Your ref
Our ref TL /3/2013/0737
Date 7th February 2014

Planning application no: 3/2013/0737

Proposal: Residential development of up to 62 dwellings (revised to 43 dwellings).

Location: Hanson Garden Centre, Whalley Road, Barrow BB7 9BA.

title Indicative Site Layout 2

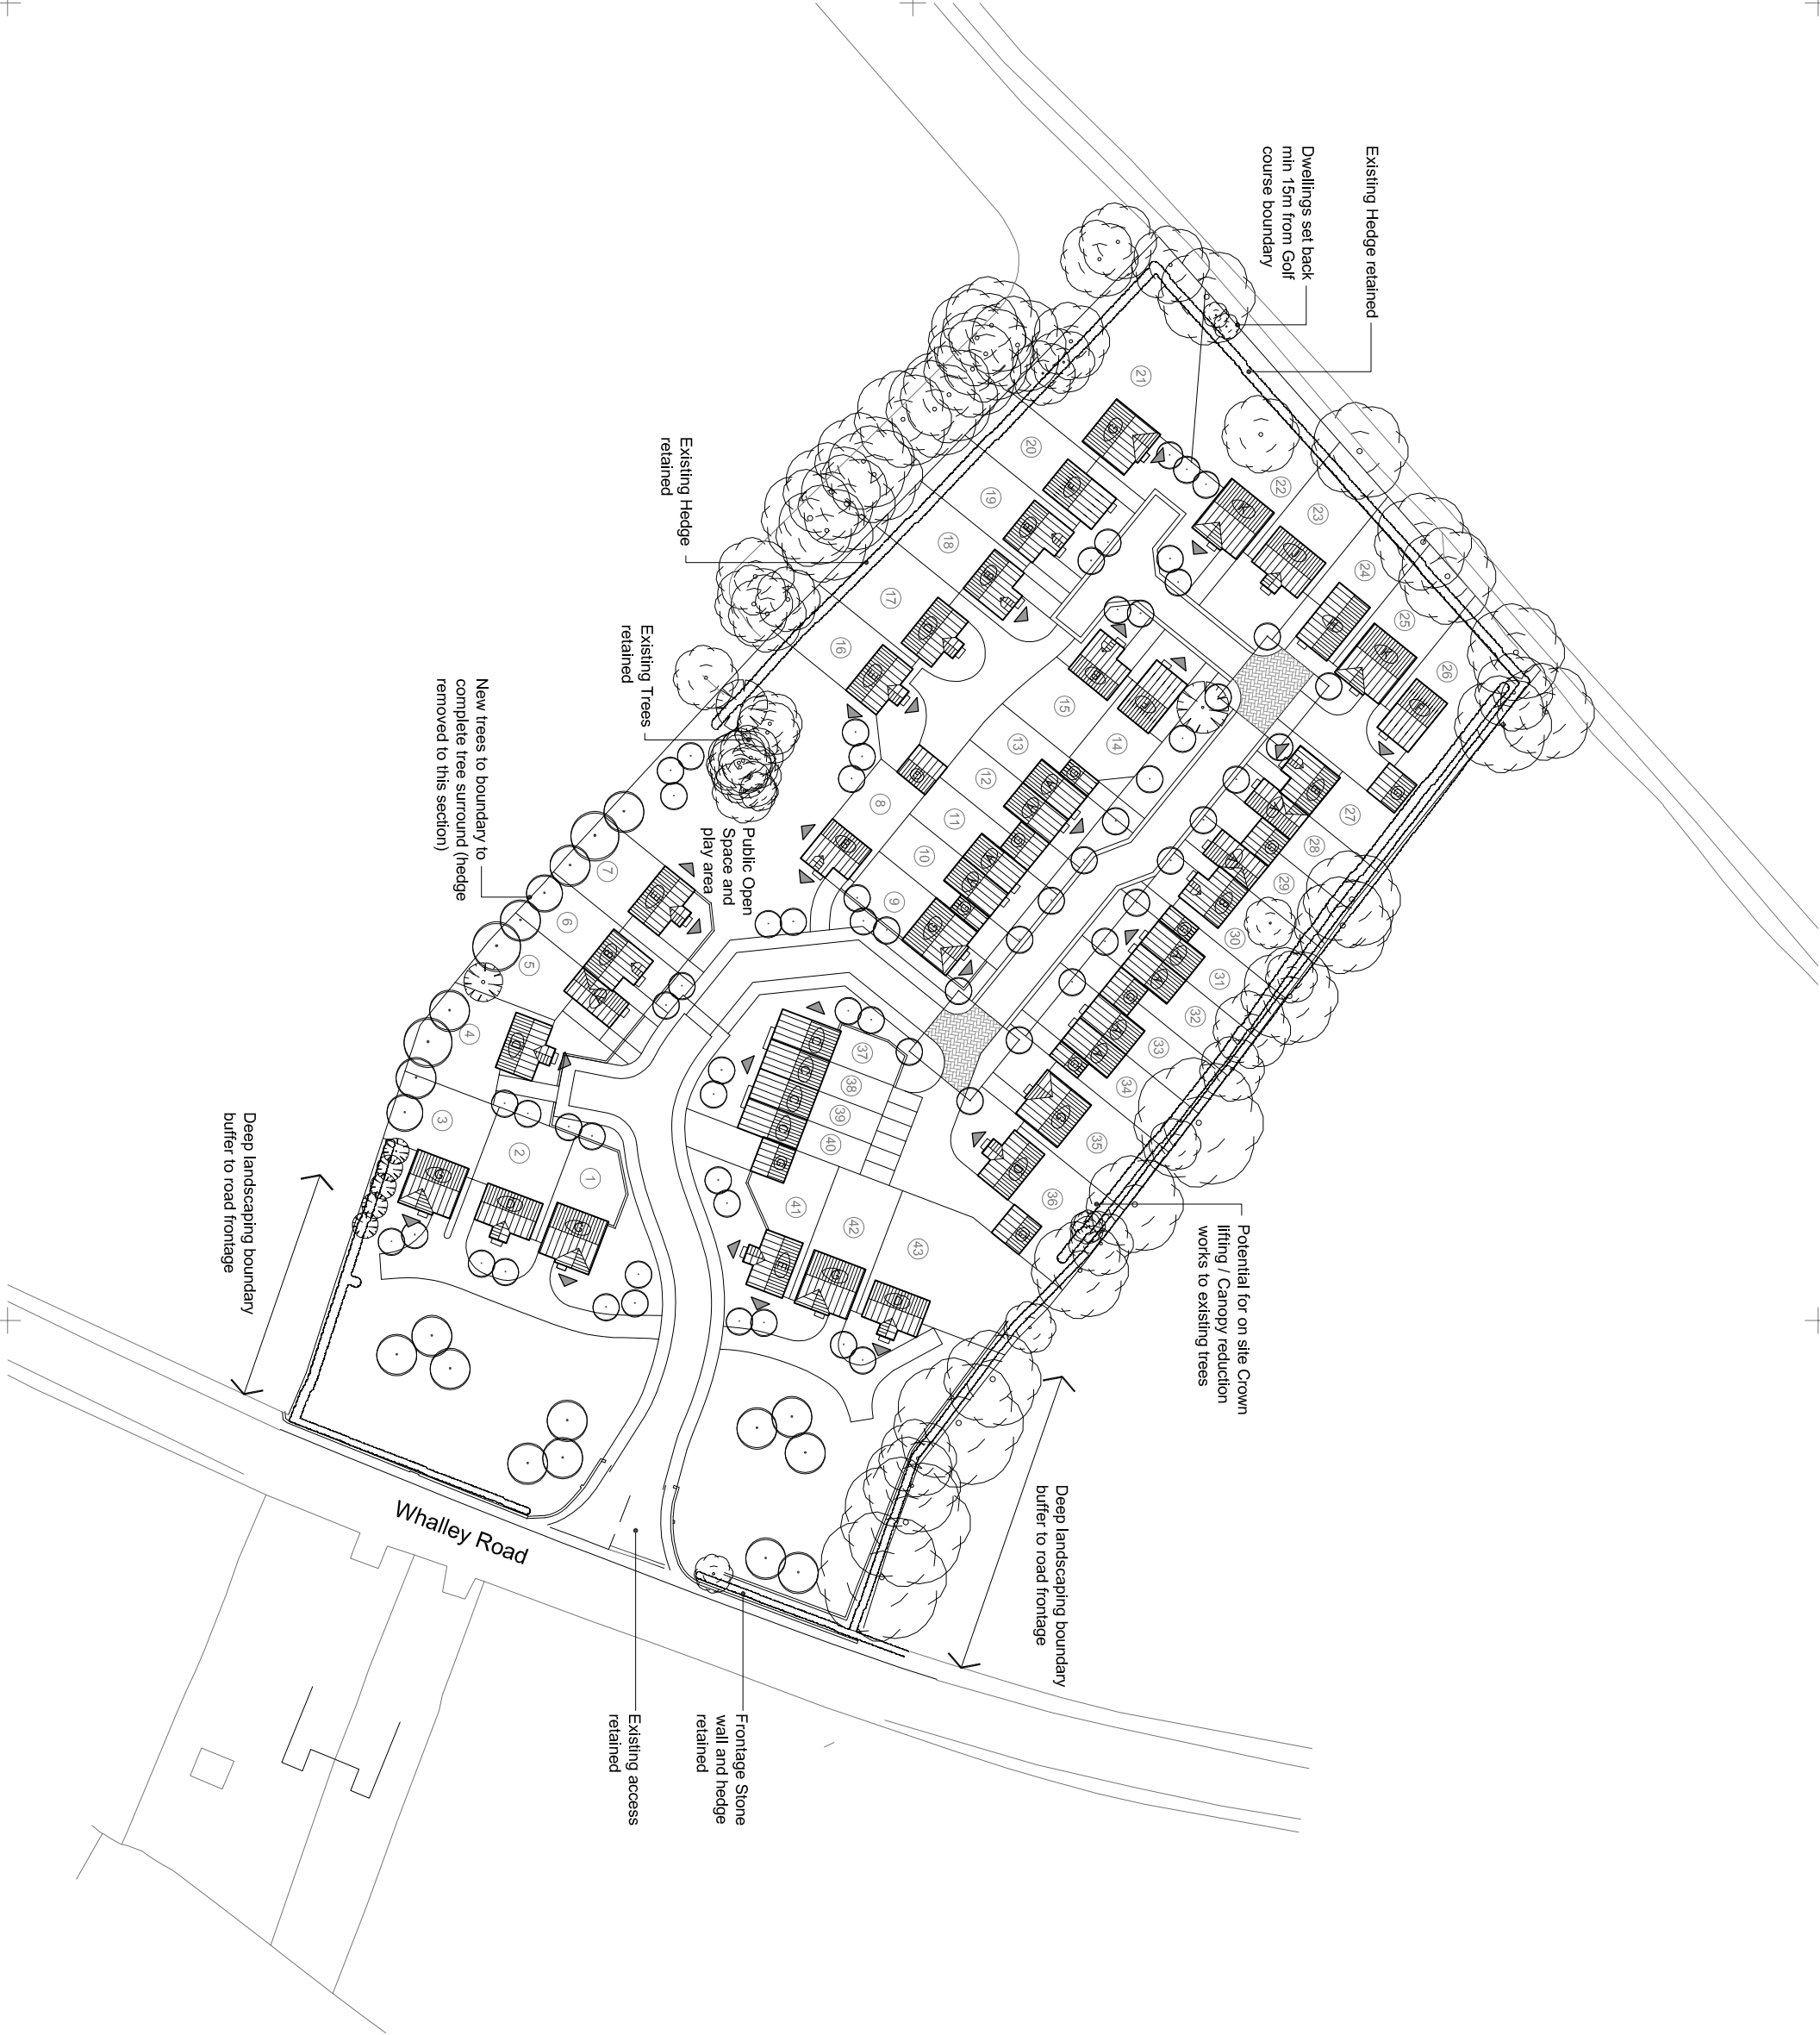
The only document submitted by the developer as a result of this amendment is a new sketch indicative site layout: SK-02 rev C. There is no other supporting documentation provided, relating for example to the estimation of the traffic flows to and from this development, the effects of this on mitigation measures required in the highway, or the ramifications for S106 monies or for works required under a S278 agreement. Consequently, I have made my own evaluation of these issues and this is set out below.

As commented previously, the proposed access for the residential development is based on the access used for the garden centre, and this is still the case for this smaller development. The geometry and size of this access is not appropriate for the residential development. I would ask that the access should be at least 5.5m wide or the same width as the estate road carriageway. 6m radius kerbing should be used to form the junction with Whalley Road.

The other comments concerning the layout design made in my letter dated 8 October apply here.
